A428 Black Cat to Caxton Gibbet improvements

TR010044

9.127 Applicant's Responses to the Secretary of State's
Consultation Letter dated 31 May 2022

June 2022

Figure 8 – A428 bridge proposal

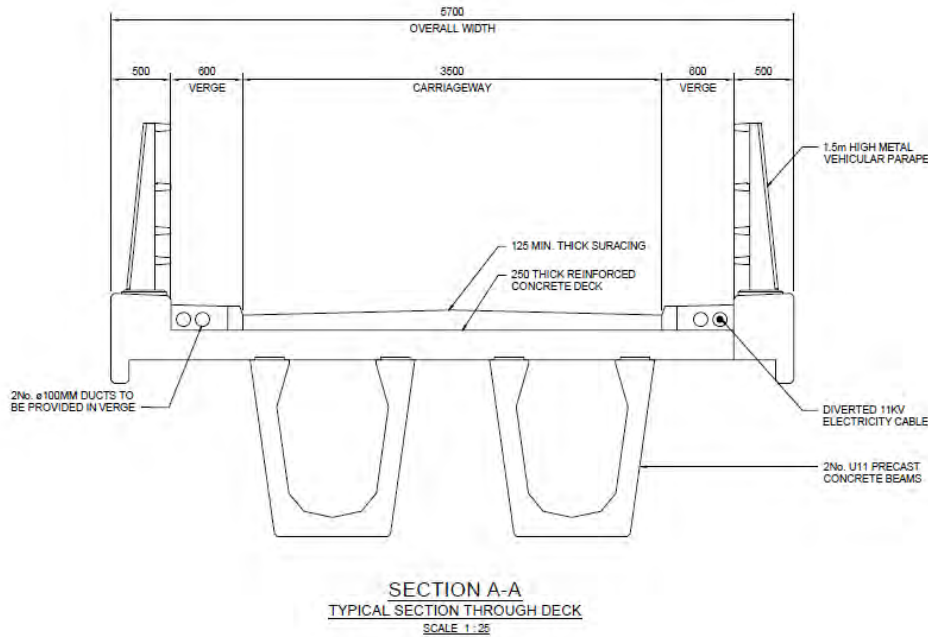
6	<p>Question:</p> <p>Request for an update from the Applicant on the access bridge proposed over the A428 at Top Farm</p> <p>The Secretary of State notes that at the close of Examination, there was an agreement in principle between the Applicant and Bidwells, representing the executors of N A Alington Little Barford Estate, for an overbridge of sufficient width to enable safe clearance for 6m wide machinery [REP10-077]. The Secretary of State requests confirmation from the Applicant and Bidwells whether an agreement is now in place for this bridge. If no agreement has been reached, the parties are asked to provide an update of the current position.</p> <p>Answer:</p> <p>During the course of the Examination, the Applicant entered into discussions with Bidwells, on behalf of the executors of N A Alington Little Barford Estate (the Executors), in an attempt to reach agreement on the width between bridge parapets required for the overbridge. Previous discussions, including email correspondence from Bidwells dated 11 January 2022, requested a 6m distance between the parapets to facilitate the movement of larger farm machinery. The Applicant agreed to provide a 6m clear width between bridge parapets</p>

Figure 1 'Cross Section of Proposed Top Farm Bridge' illustrates the basis of the current design which includes a 6m clear width as previously requested and agreed with Bidwells. Notwithstanding this, in email correspondence exchanged following receipt of the Secretary of State's request for clarification and further information (dated 31 May 2022) Bidwell's has now sought to further increase the distance required between parapets to 6.5m.

comprising a 4.8m carriageway and two 0.6m verges. In reliance on this agreement, the Applicant has subsequently commenced detailed design in good faith based on these principles.

The Applicant does not consider this further request to be reasonable and it has not been justified based on information provided by Bidwells. The Executors' Written Representation **[REP1-096]** documents the restriction currently managed by the farm created by the width of the railway underpass. As a result, farming machinery is currently transported to the affected part of the farm via local roads which are typically less than 3m wide in each direction. All of the larger pieces of machinery used on this part of the farm must be transported using the local road network. An average carriageway width of less than 6m is currently available in the event of using exceptional convoy. As the equipment can be adjusted to travel on narrow local roads, the Applicant considers a 6m width between parapets is more than sufficient.

The Executors' Written Representation **[REP1-096]** illustrates that the widest of the agricultural vehicles currently in use at Top Farm is 4.3m without the header. Whilst the combine header is 12m wide in use, when transported, it is usually detached from the combine and transported on a separate trailer between fields. The width of the header trailer is narrower than the agricultural vehicle required for towing.

Should the Executors consider that the time taken to adjust the machinery between fields is an increased cost to farming operations, this can be considered as part of any compensation claim. Furthermore, the width of 6m between parapets has been accepted by other agricultural land owners on this Scheme and the recently completed A14 scheme. The Applicant therefore considers that this width is compatible with farming operations.
